DEPARTMENT OF PARKS AND COMMUNITY SERVICES

October 13, 2023

Subject: Bull Hill and Rolling Meadows Sketch Plan (SKP233)

# ROLLING MEADOWS/ BULL HILL SKETCH PLAN AMENDMENT

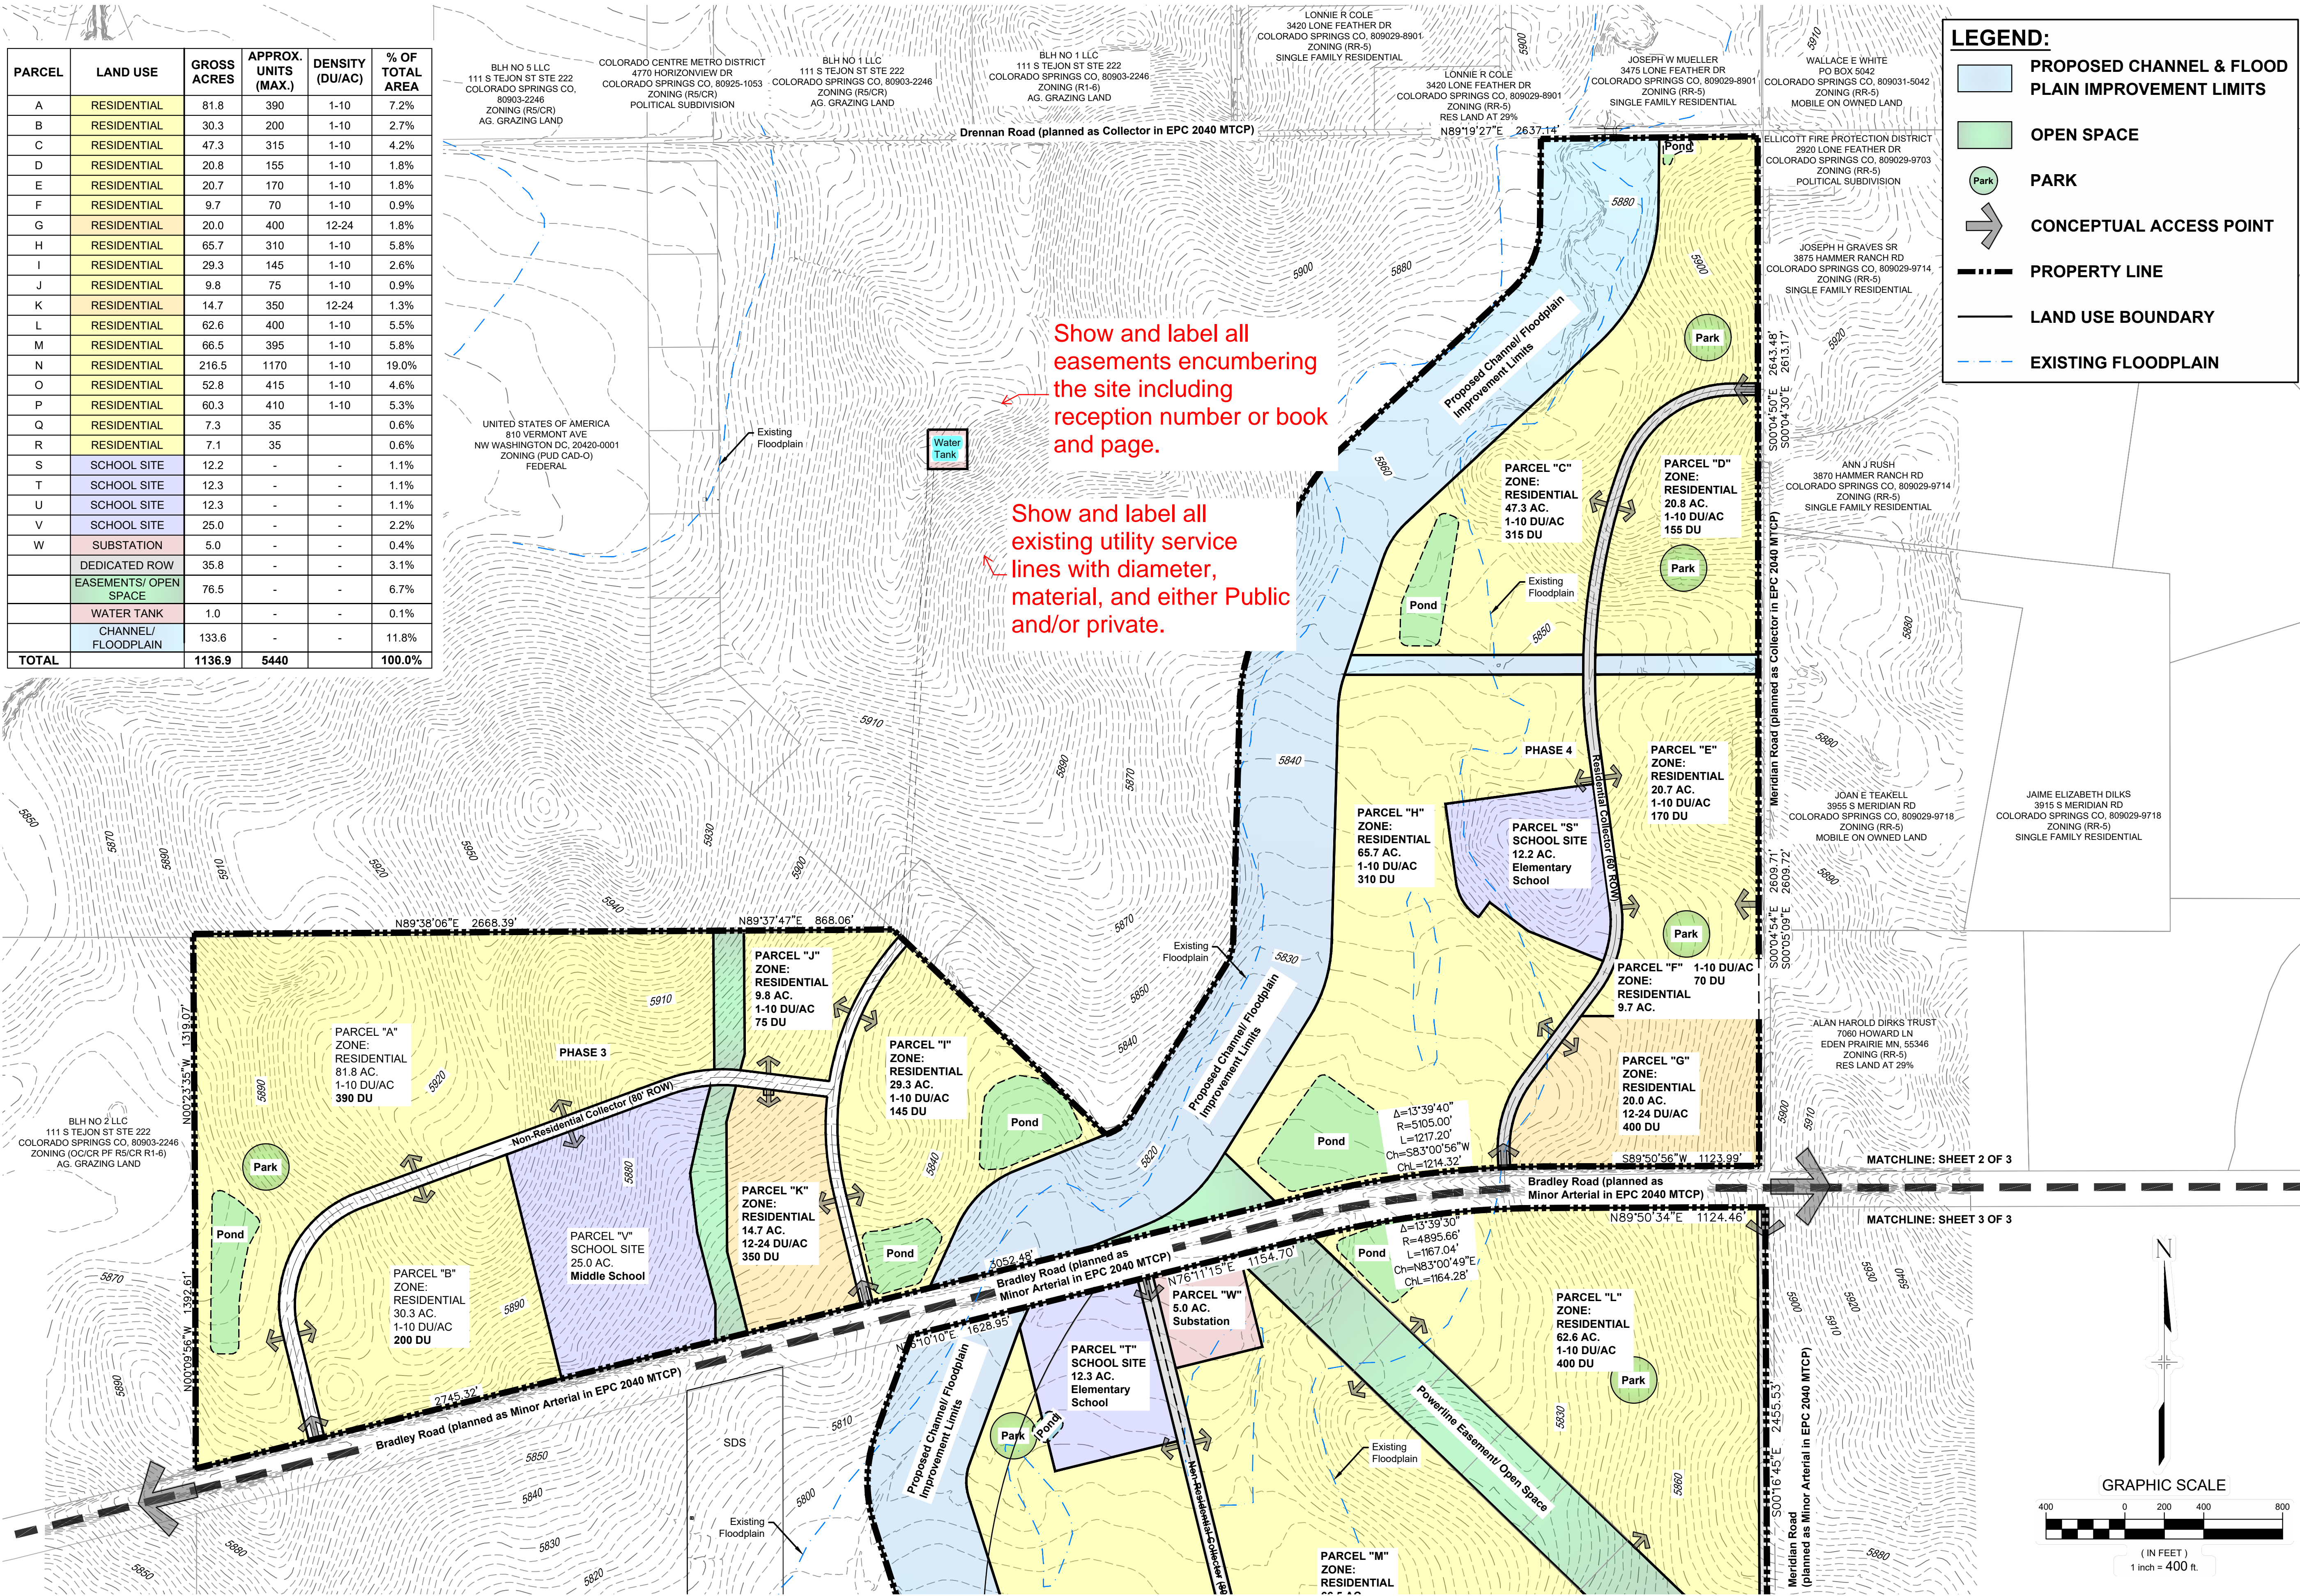
The proposed Bull Hill and Rolling Meadows sketch plan totals 1,520 acres and is proposes 5,440 attached and detached housing units. However, it does not clearly identify the location of different residential densities because single-family detached housing is shown as 1-10 DU/ace, and multi-family residential

areas are shown as 12-24 DU/acre. These wide ranges are not consistent with typical sketch plan applications. As submitted, the sketch plan lacks sufficient detail to evaluate different land uses, residential densities, circulation patterns, and considerations of proposed park locations, open spaces, and trail corridors.

The letter of intent mentions that the powerline easement is a potential trail corridor which may provide trail connections to adjoining neighborhoods. However, there are no trail corridors shown on the sketch plan drawings. Consistent with the Land Development Code (LDC) guidelines for sketch plan applications, staff requests that the applicant show all public trails, including County and non-county trails and bicycle routes on the sketch plan drawings. It would also be helpful to better understand how trail connectivity will be provided across major roadways such as Bradley Road and to adjoining subdivisions such as Lorson Ranch.

The sketch plan amendment shows what appear to be neighborhood parks on the plan, but the size is not specified. The letter of intent states that the parks are pocket parks which are typically less than 1 acre in size. There does not appear to be any community parks of a minimum 24-acre size on the plan. This is a deficiency that should be addressed. Pocket parks are not intended to solely serve a community of 5,440 dwelling units.
